# CITY OF ALBUQUERQUE

January 8, 2013

**Re: Mesa Del Sol Community Swimming Pool  
Grading and Drainage Plan  
Engineer's Stamp date 12-21-12 (R16/D005)**

**GRADING AND DRAINAGE PLAN**

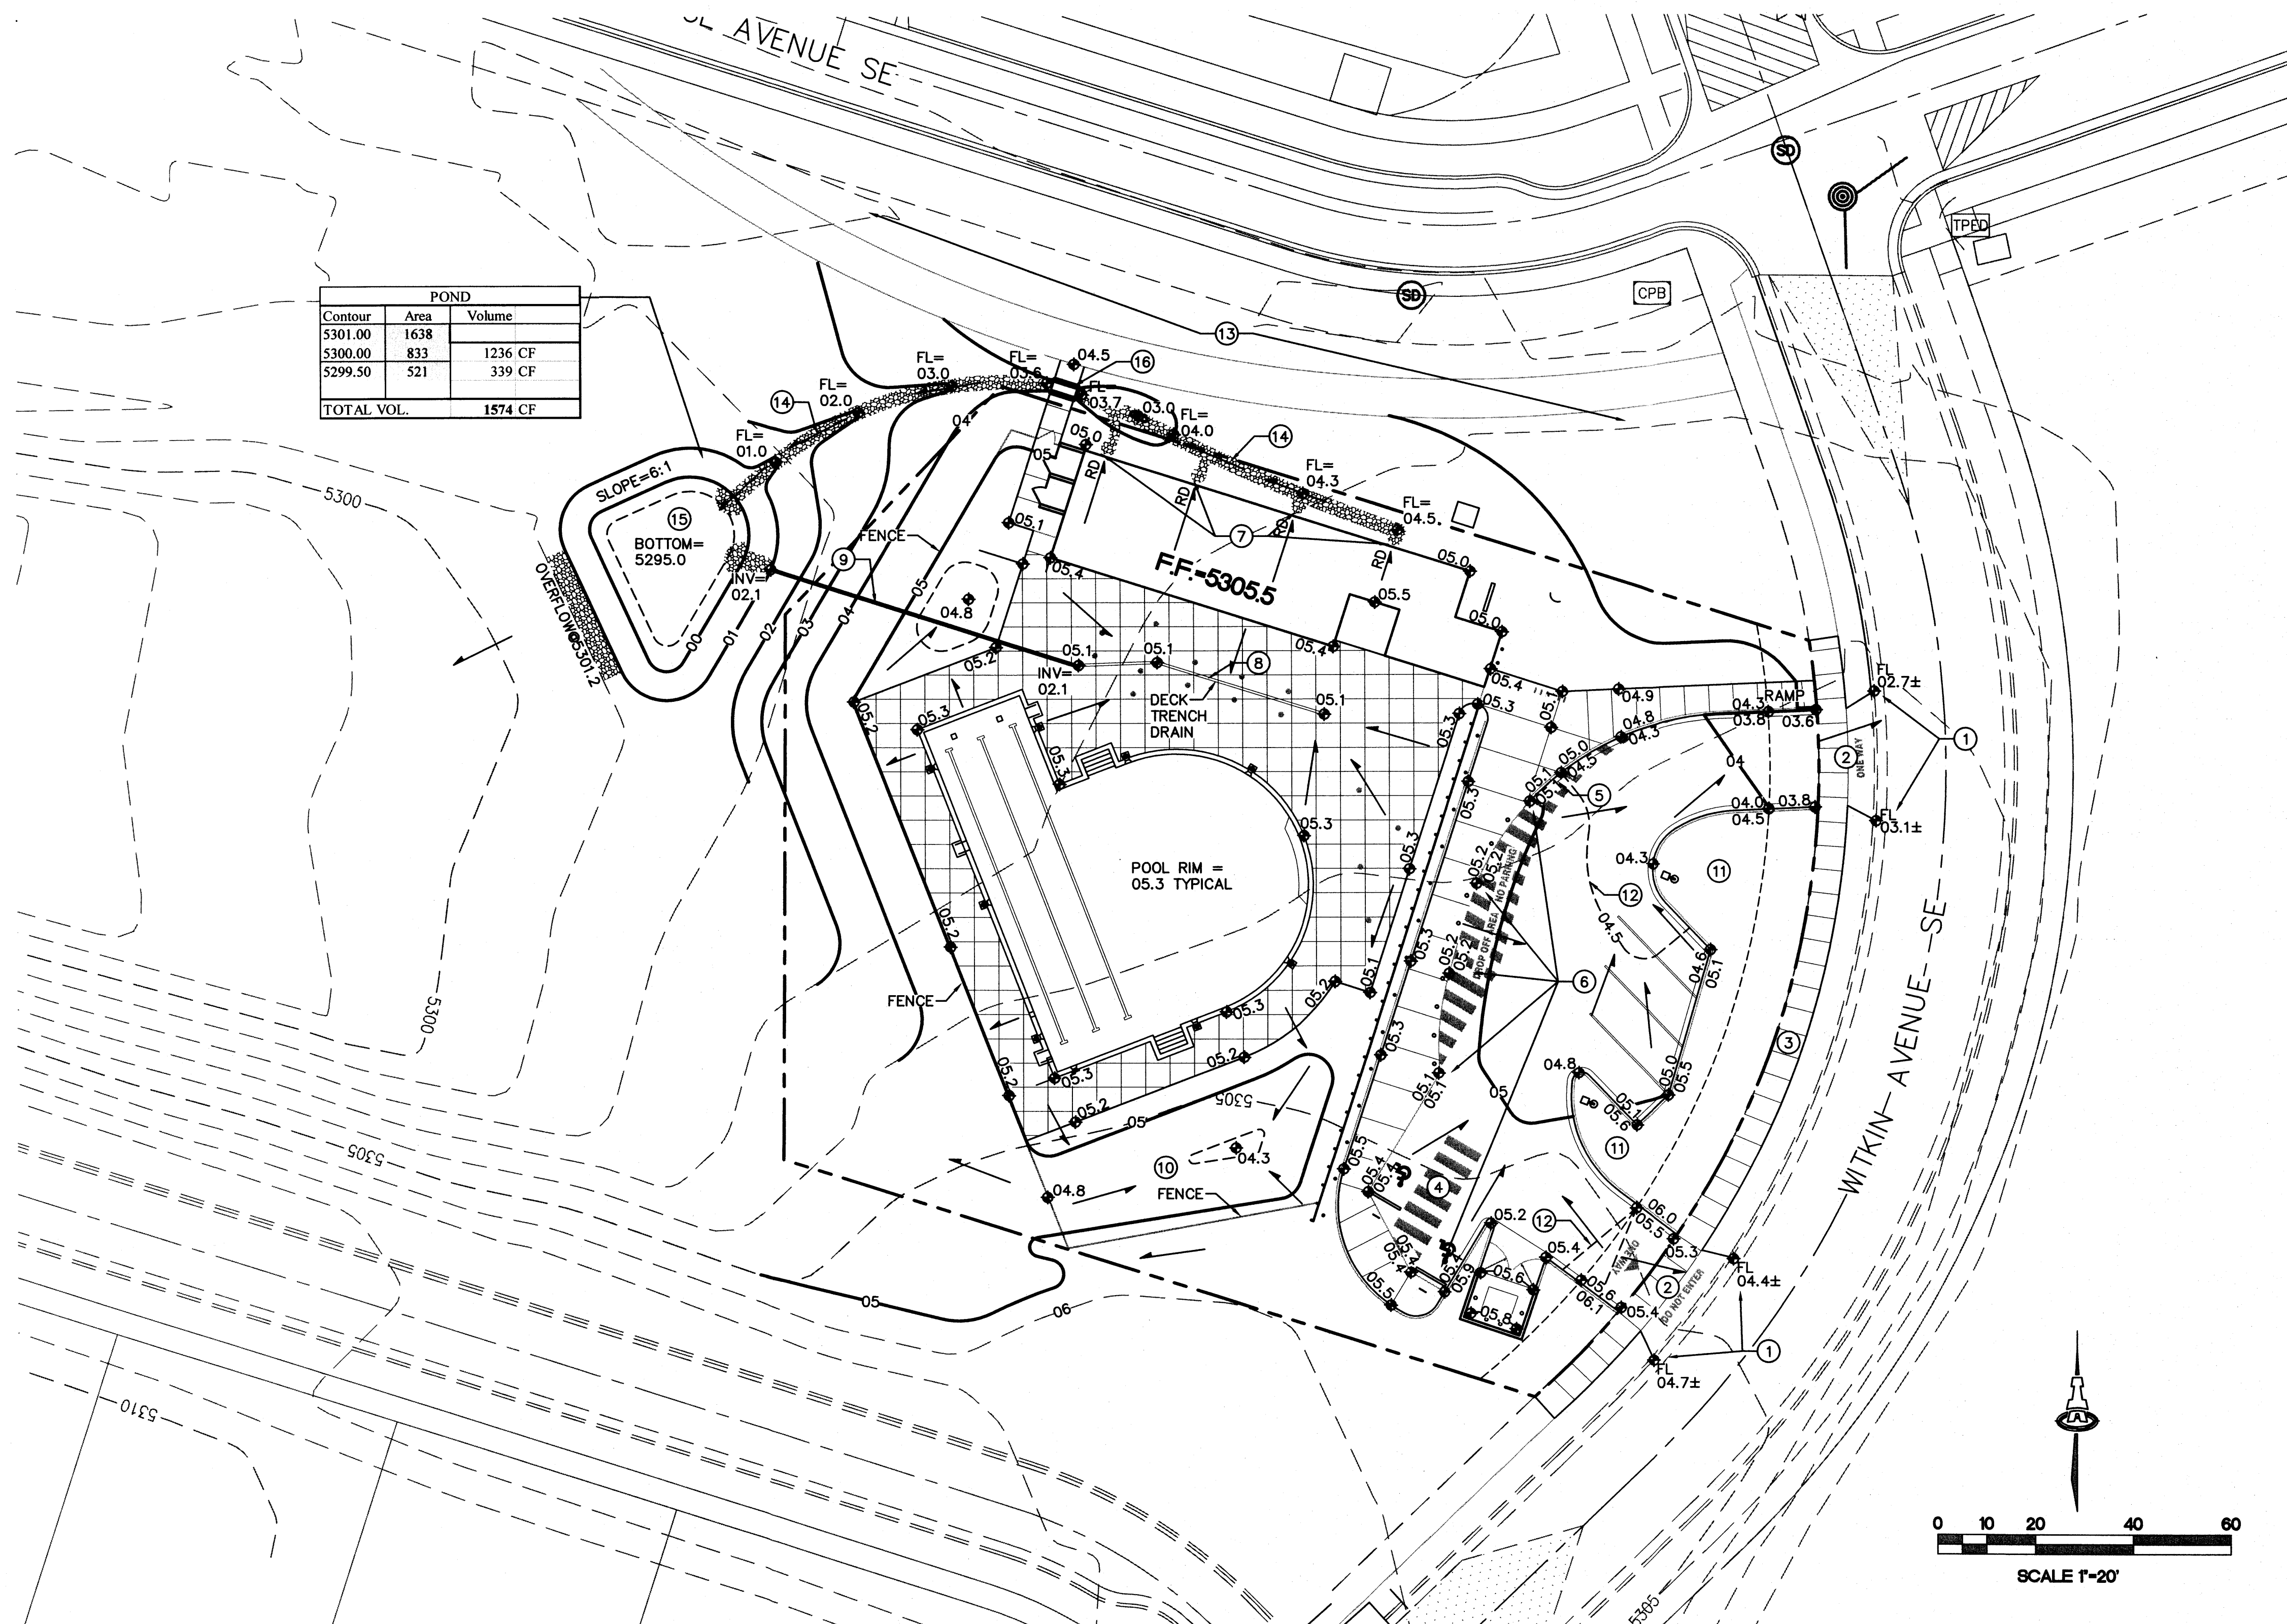
Based upon the information provided in your submittal received 12-26-12, the above referenced plan can not be approved for Building Permit until the following comments are addressed.

- Show the site as containing two basins. What are the flows?
- How are the flows reaching the pond on the north side of the site? It appears that the flows are headed towards the street.
- The side walk on the north side of site is ending at the street. Why? The plan shows a chain link fence when in fact there is a CMU wall, where the side walk would end.
- Take the 8" SD pipe to the bottom of pond. What size and type of inlet is located at note 9? Also at this location, note states extend deck drain outlet pipe. What deck drain?
- Note 13 is confusing, please clarify.
